Demolition of existing building & construction of 1 No retail unit & 3 No. flats with associated external works & access. This application affects the setting of listed buildings & may affect the character & appearance of the River Road, Littlehampton Conservation Area.

Littlehampton Covered Market 26-28 Surrey Street Littlehampton

Thank you for your internet representation made on 28th April 2020 which has been recorded as **'an objection'** with the comments as follows:

EAST ELEVATION

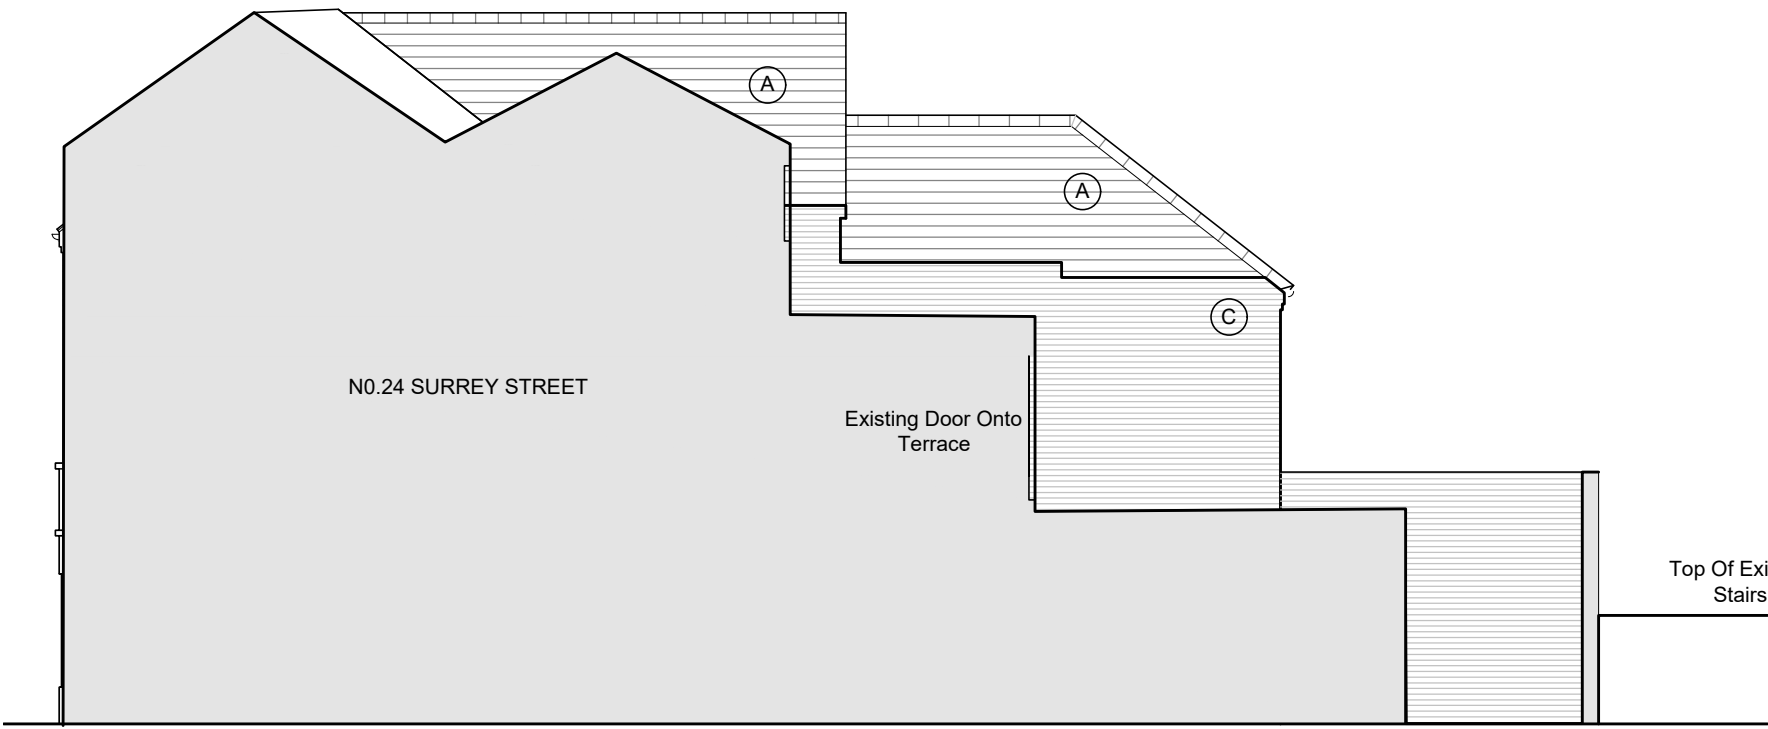
The new front elevation is out of step with the original building and with the adjacent mid 19th century buildings to the north and the pub to the south. It would be better if the windows on the second floor could be dormers (as in the original building) and were made of natural wood with horizontal sash sliding mechanisms and not "white sash-effect windows". Similarly the roof building material should be of natural slates rather than "false slate tiles".
